WEST SUSSEX COUNTY COUNCIL CONSULTATION

TO:	Arun District Council FAO: Simon Davis
FROM:	WSCC - Highways Authority
DATE:	18 December 2020
LOCATION:	Land at Stakers Farm, North End Road, Yapton
SUBJECT:	Y/72/20/RES Approval of reserved matters following outline approval Y/44/17/OUT for the erection of 70 No. dwellings, public open space, play area, drainage & landscaping. This application affects the character & appearance of the Main Road/Church Road Yapton Conservation Area & affects the setting of Listed Buildings. Amended plans received.
RECOMMENDATION:	No Objection

PLOTS
51-56

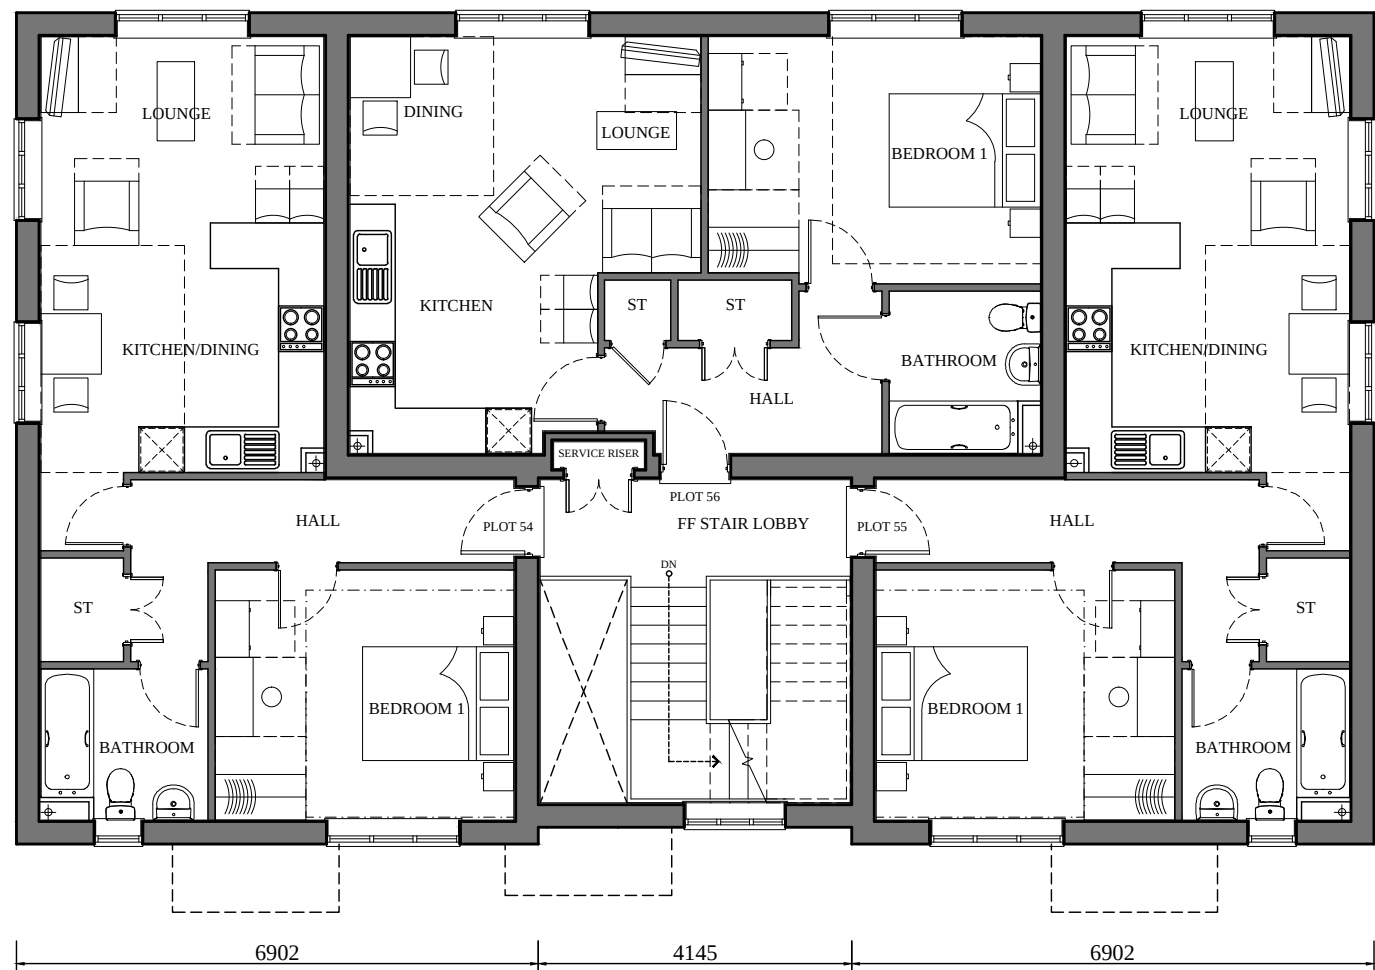
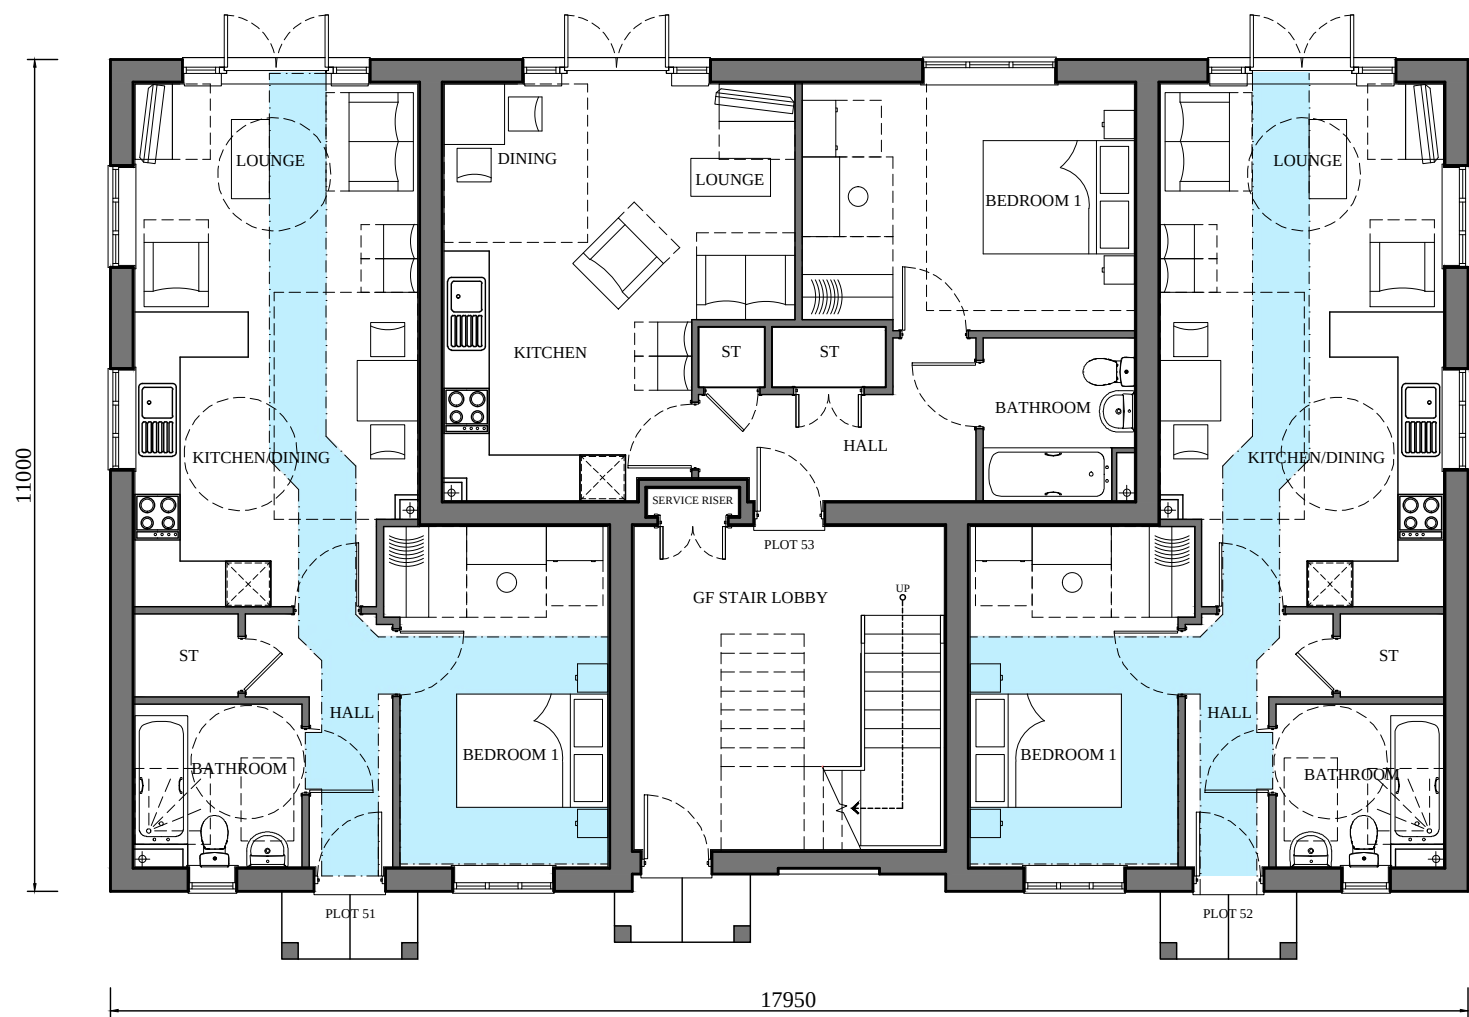
- 2. Bicycle Parking** - From an inspection of the plans, there appears to be sheds in each plot which could be used for cycle storage, where garages are not present. It is presumed that the 12 x cycle parking shared facility is situated south of plots 51-56 (6 x 1 bed flats). The LPA should consider whether the level of detail provided satisfies the requirement.

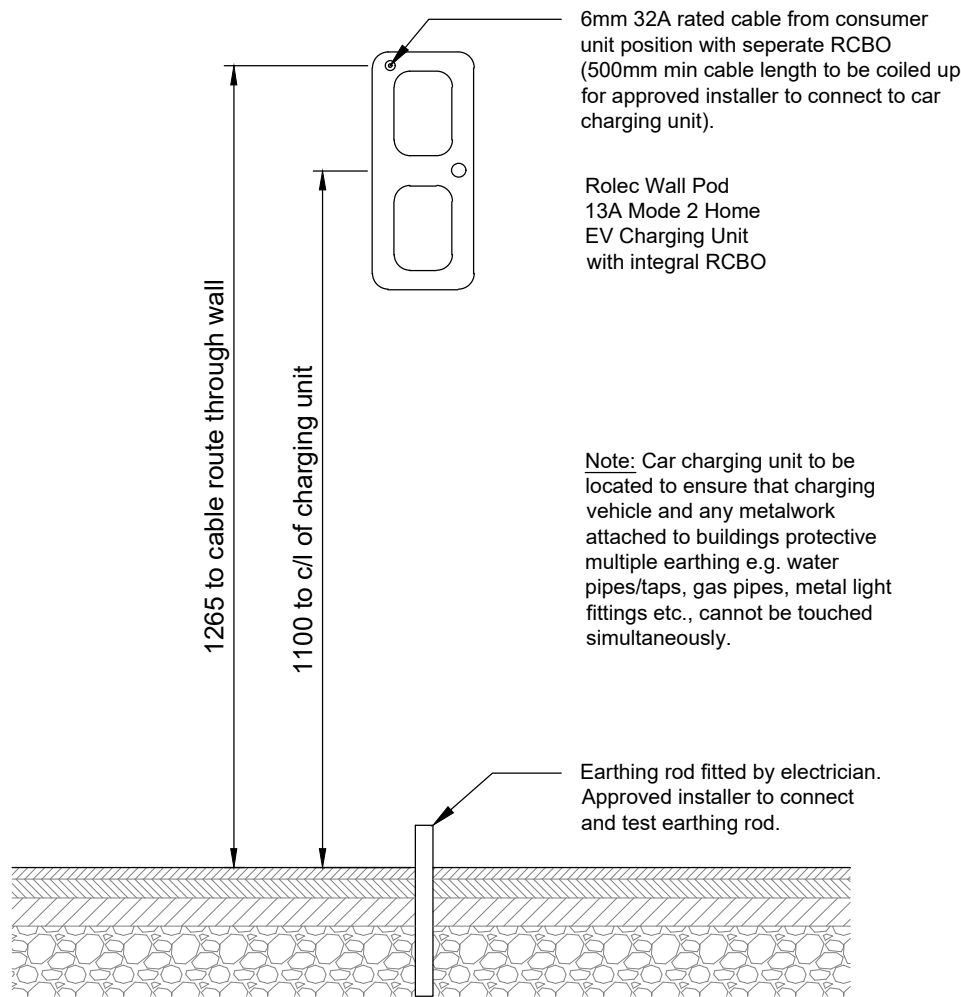
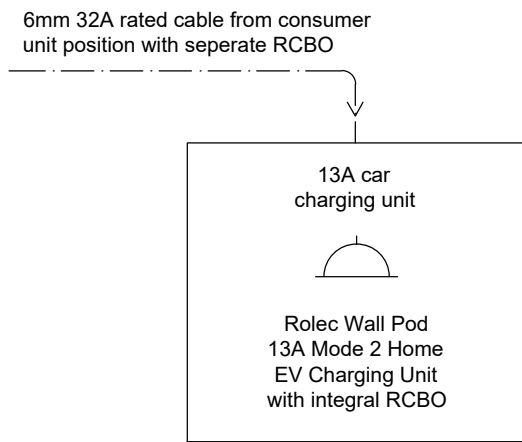
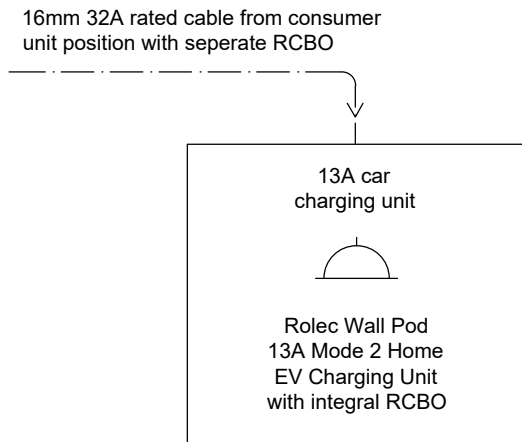
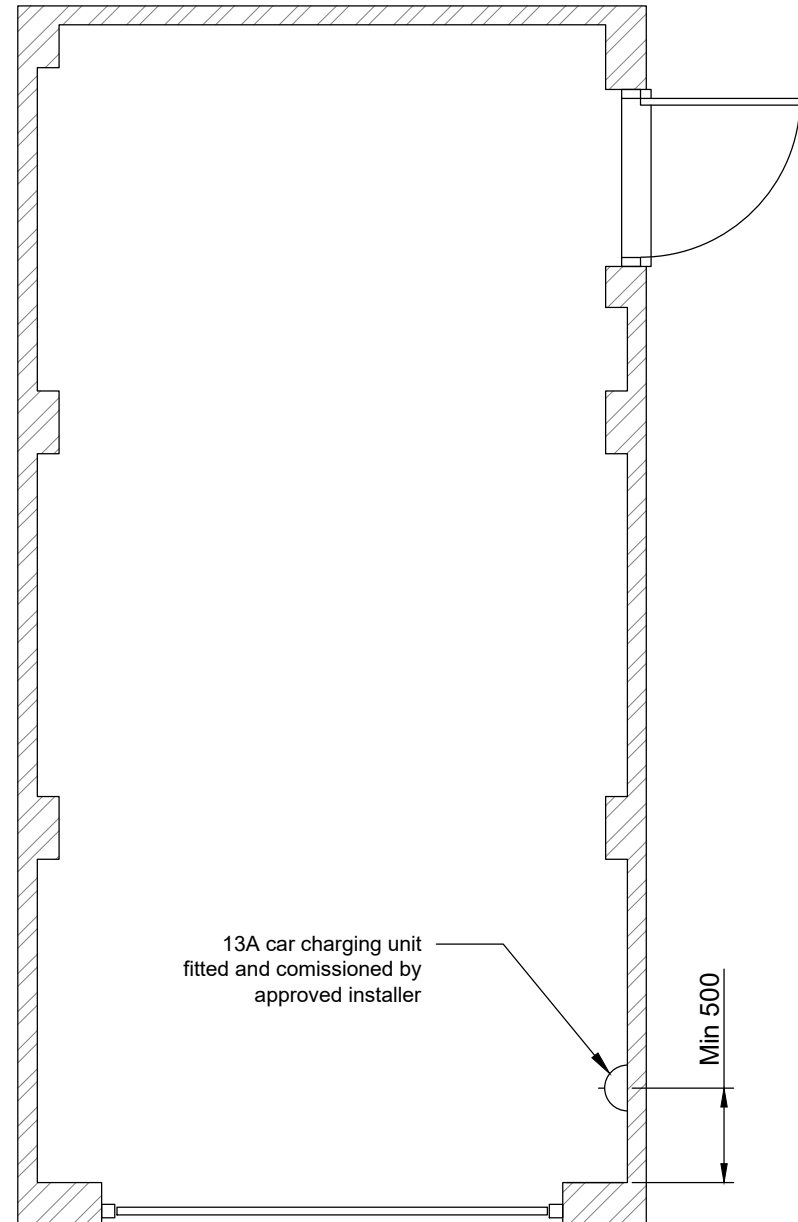
- 3. Car parking** was assessed as appropriate under previous comments but it is also noted that an electric vehicle (EV) charging layout has now been provided to show location of EV points within garages.
